**From:** Sarah Burrow <Sarah.Burrow@arun.gov.uk>  
**Sent:** 01 November 2019 14:44  
**To:** Planning.Responses <Planning.Responses@arun.gov.uk>  
**Cc:** Simon Davis <Simon.Davis@arun.gov.uk>  
**Subject:** RE: Planning Consultation on: BE/109/19/OUT

### **Engineers Comments Regarding Surface Water Drainage Design**

**APPLICATION NO:** BE/109/19/OUT

**Description of Works:** Outline application with some matters reserved for up to 46 No dwellings together with access. This application is a Departure from the Development Plan.

Figure Title	
Surface Water Drainage Strategy	
Project Name	
Land East of Shripney Road	
Project Number	Figure No.
1620004241	04
Date	Prepared By
September 2019	MA
Scale	Issue
1:917 @A3	-
Client	
Ashmarden Ltd Retirement Benefit Scheme

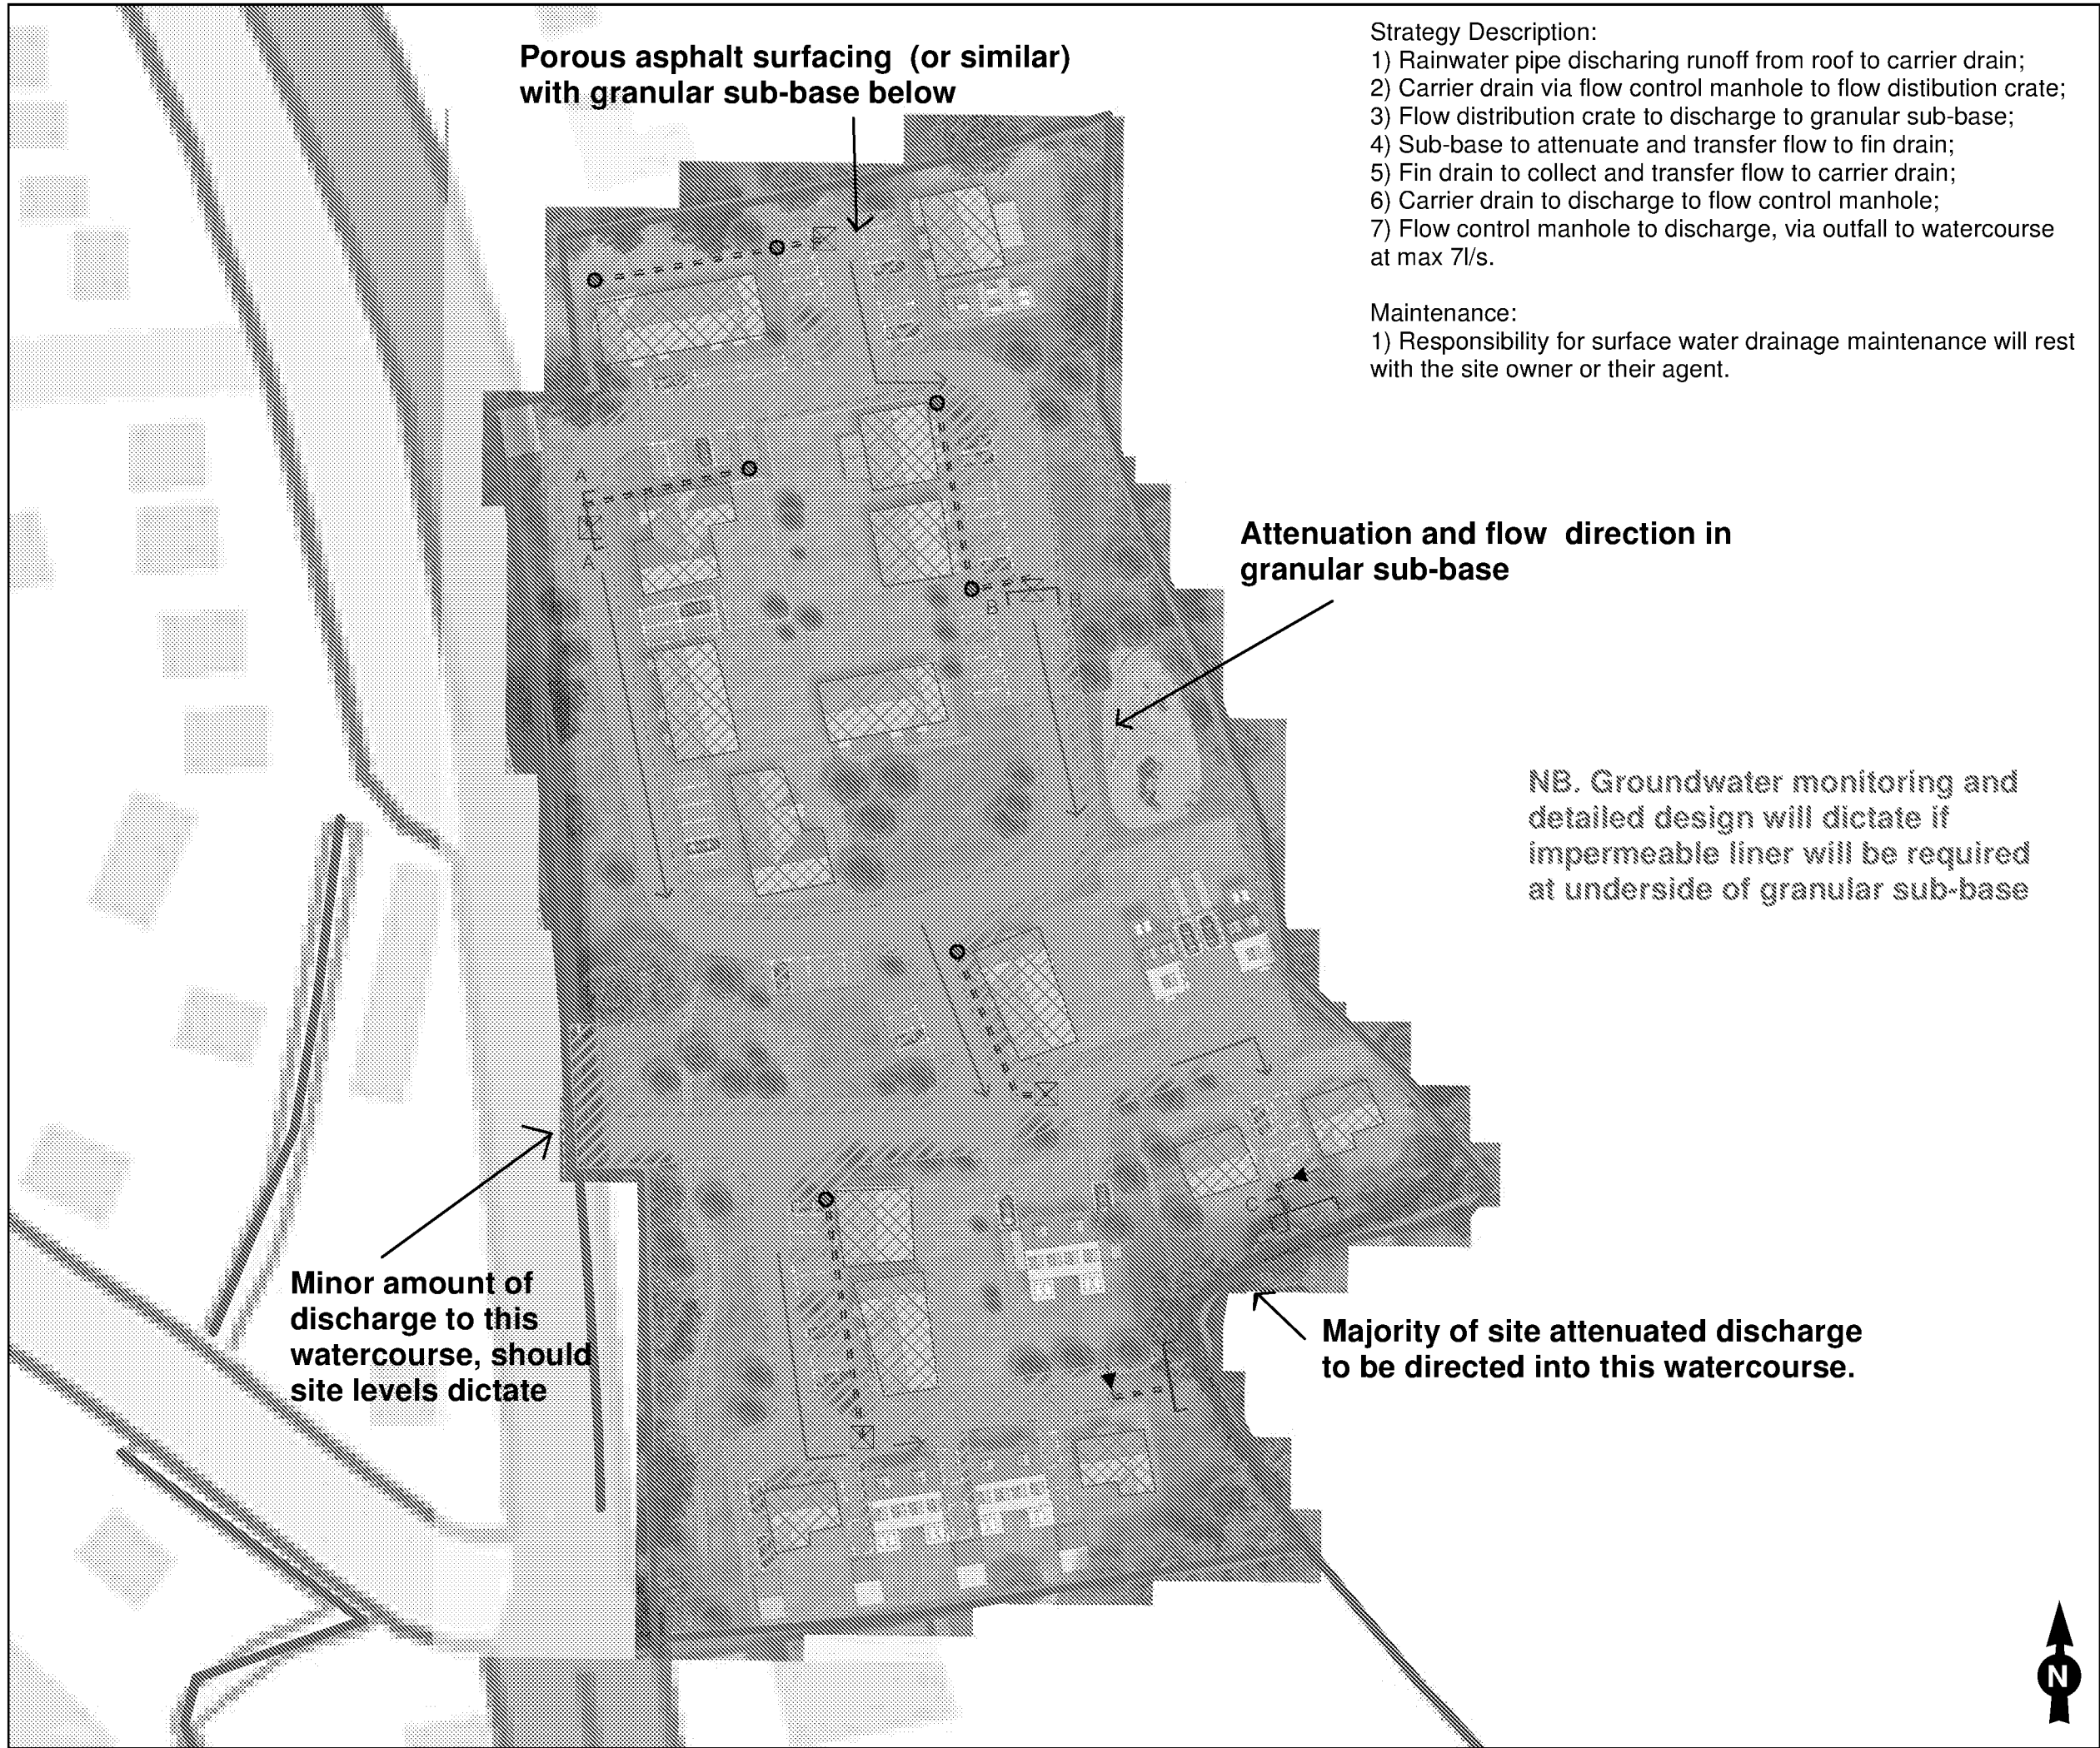
The surface water drainage strategy is proposing to use permeable paving (infiltrating or lined depending on groundwater and infiltration test results) and an underground attenuation tank with restricted discharge to two boundary watercourses. The strategy discounts the use of any open features (balancing ponds, swales and detention basins) on the basis of 'Limited space available space [sic] within the proposed development site.' Surface water drainage must be considered at the earliest opportunity and form part of the layout development process, therefore having limited space is not a reasonable excuse. Leaving drainage design until after a layout has been agreed will likely unduly prejudice drainage design and not allow for the hierarchy for sustainable drainage to be followed.

Therefore it is asked that the applicant reconsider the layout of the proposed development in order to incorporate open surface water drainage features to minimise storage in underground attenuation tanks. It is believed that this is possible without changing the location of buildings. It may also be possible to extend the permeable paving to provide a blanket infiltration solution.

Furthermore the applicant proposes discharging some of the surface water from the site to the watercourse on the western boundary. There are known capacity issues at this watercourse and it may be necessary for the applicant to carry out remedial works to the watercourse and downstream culvert in order to gain permission to discharge to it.

The applicant will need to ensure that no structures including boundary fences are located within 3 metres of the near bank of any watercourse.
